3 October 2012  
Ref No: 1675-1003

**Pacific Pines MP 07\_0026 Concept and Project Approval MOD 4**

The summary information provided below addresses the issues included in your correspondence of 21<sup>st</sup> August, and provided further explanation to assist the department in reviewing the enclosed material.

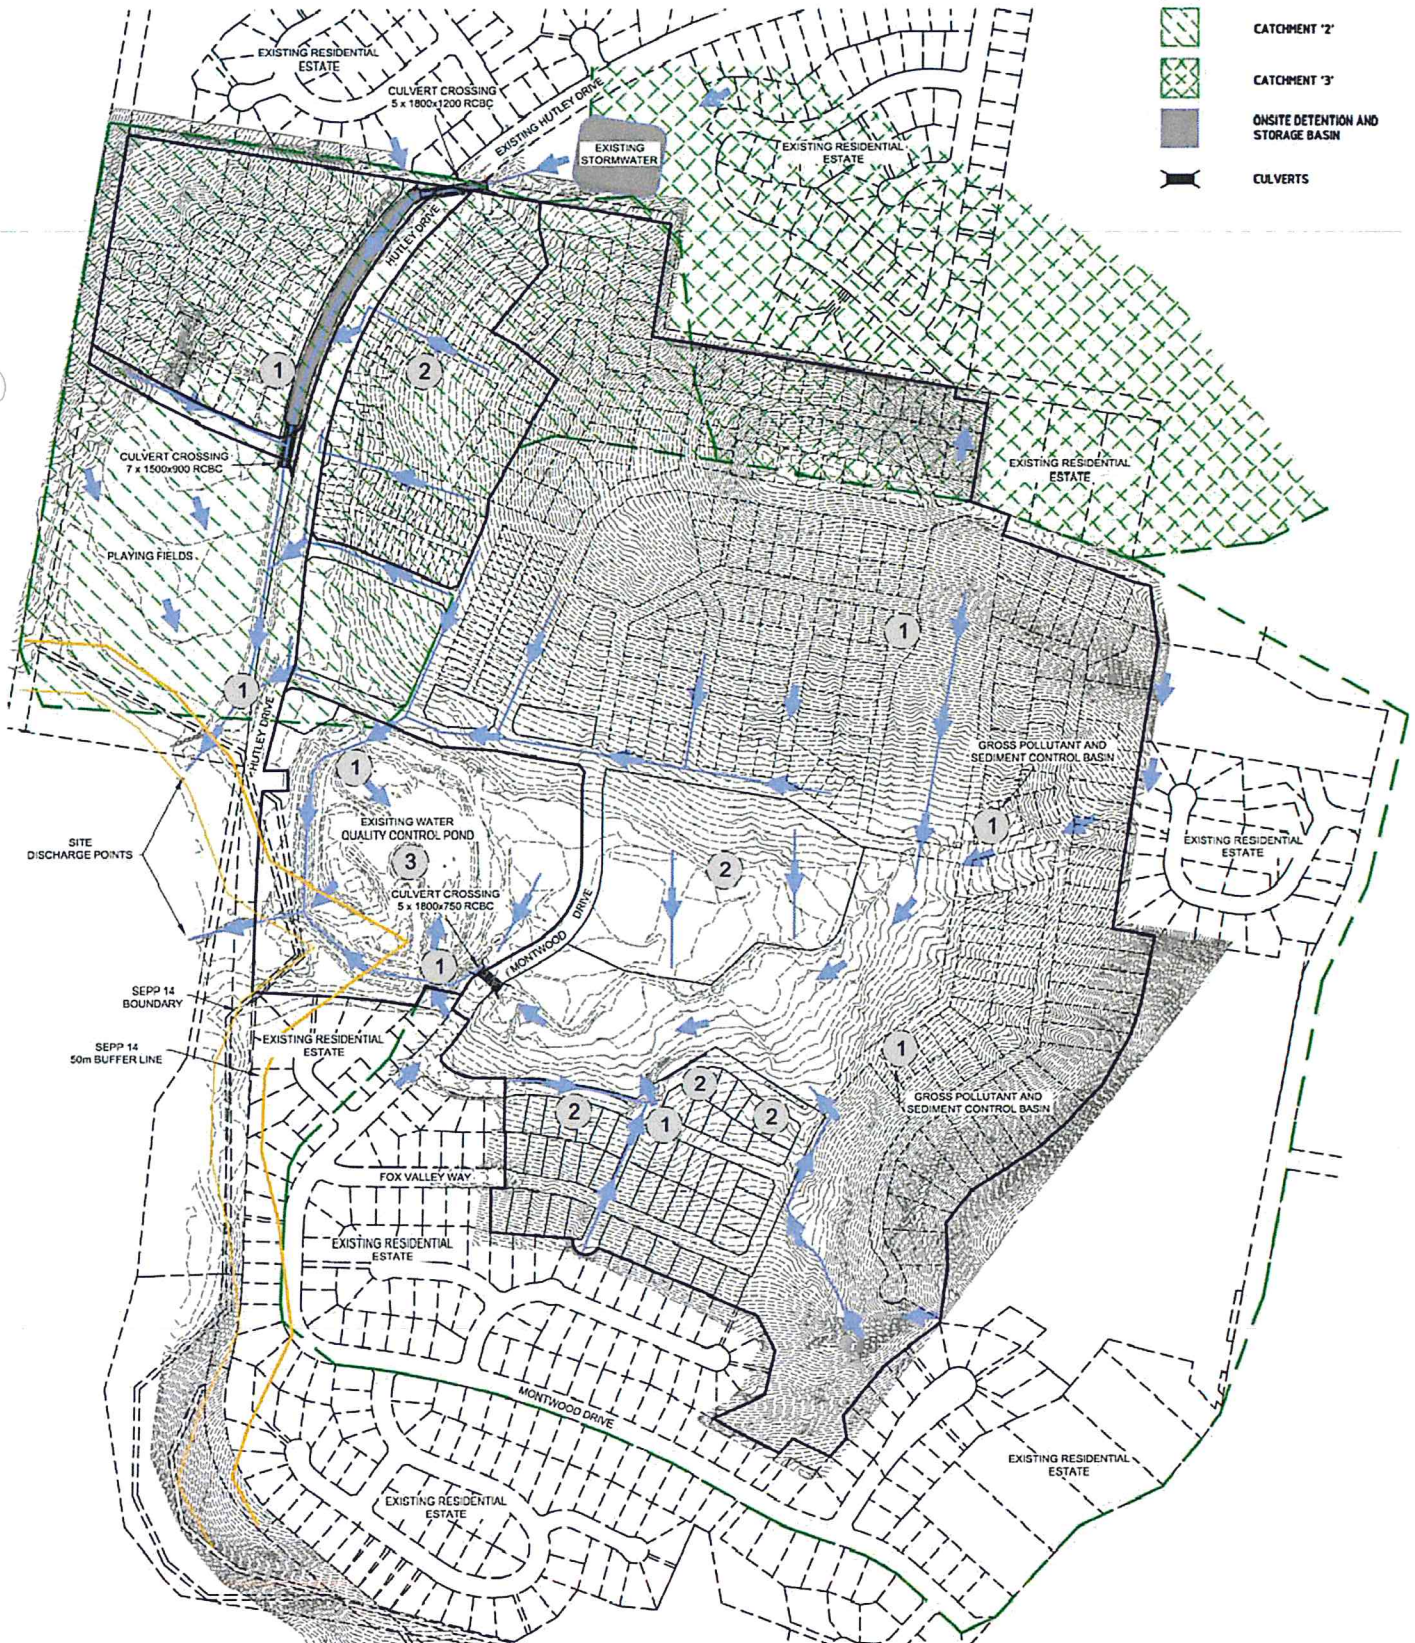
*Illustration C7 shows sediment ponds in the conservation zone – advice to SEWPaC confirms there will be no drainage infrastructure in the conservation zone area. Please confirm that the revised stormwater layout and services layout will not include any infrastructure in the conservation zone.*

Comment	Response
<i>Illustration C7 shows sediment ponds in the conservation zone</i>	Illustration revised to remove stormwater infrastructure. See attached.
<i>Illustration C3 still shows the tavern, this needs to be updated</i>	Illustration C3 was original submitted to provide an indicative example of how the Neighbourhood Centre might be developed. We do not believe that it contains any specific information that should constrain the future development of that site, which will be subject of a

Revised Illustration C7 is attached and shows that there is no longer any stormwater infrastructure located in the Conservation Zone.

The illustration shows the *function* of 'onsite detention basin and storage basin' within the Conservation Zone. This does not require nor involve the construction of any structures or earthworks within the Conservation Zone. It merely notes the current hydraulic regime where, during and immediately after significant rain events, water temporarily ponds in this central area before discharging to the water quality control ponds.

Illustration P4 - Stage 1 Stormwater Concept Plan

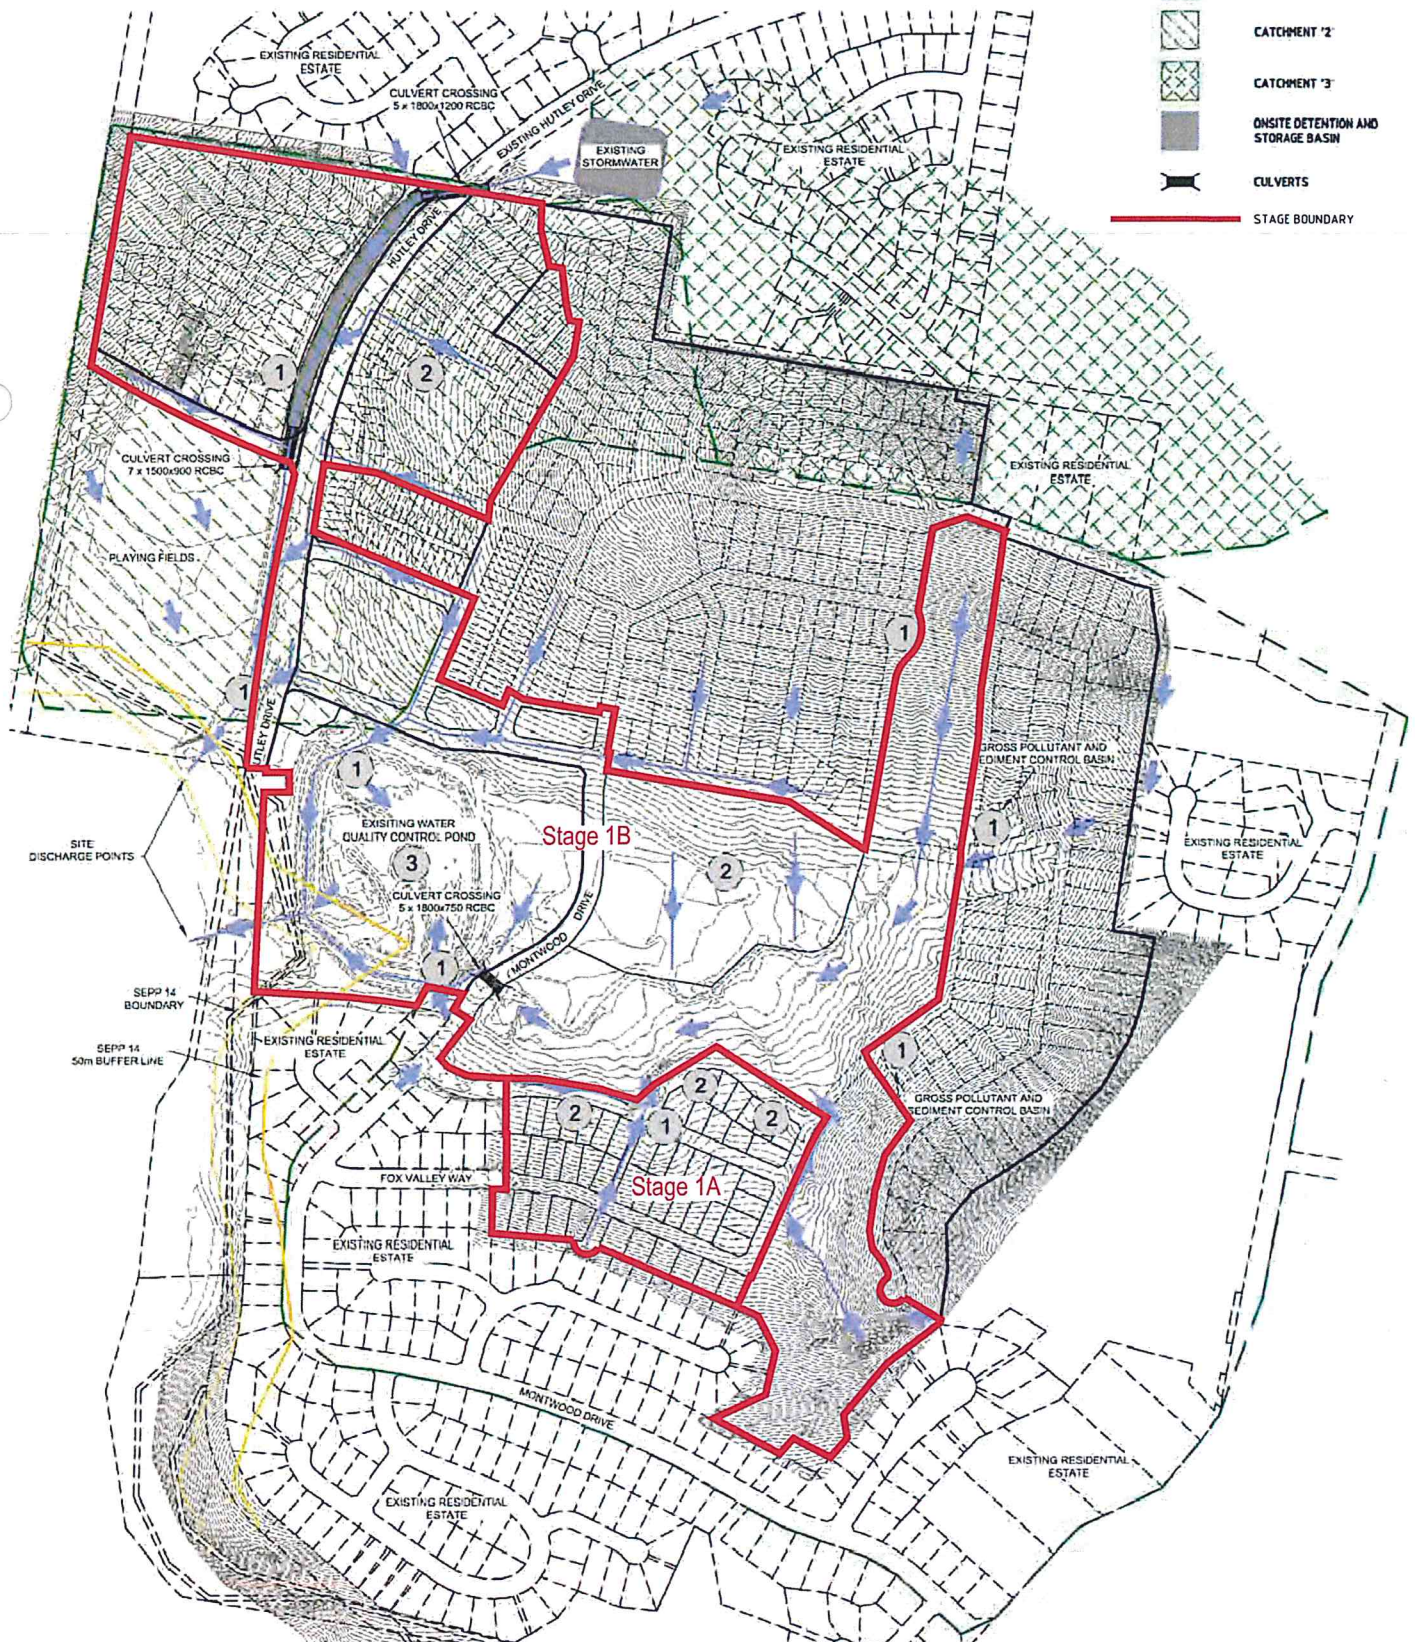
<i>Illustration P4 shows stormwater infrastructure in the conservation zone</i>	Illustration revised to remove stormwater infrastructure. See attached.
<i>Illustration P5 shows bulk earthworks in the conservation zone</i>	Illustration revised. See attached.
<i>Illustration P6 shows revised design contours in the conservation zone</i>	The revised design contours are now shown on the updated Illustration P5. It is therefore requested that Illustration P6 be removed from the list of approved plans.

Updated plans C7 and P4 enclosed.
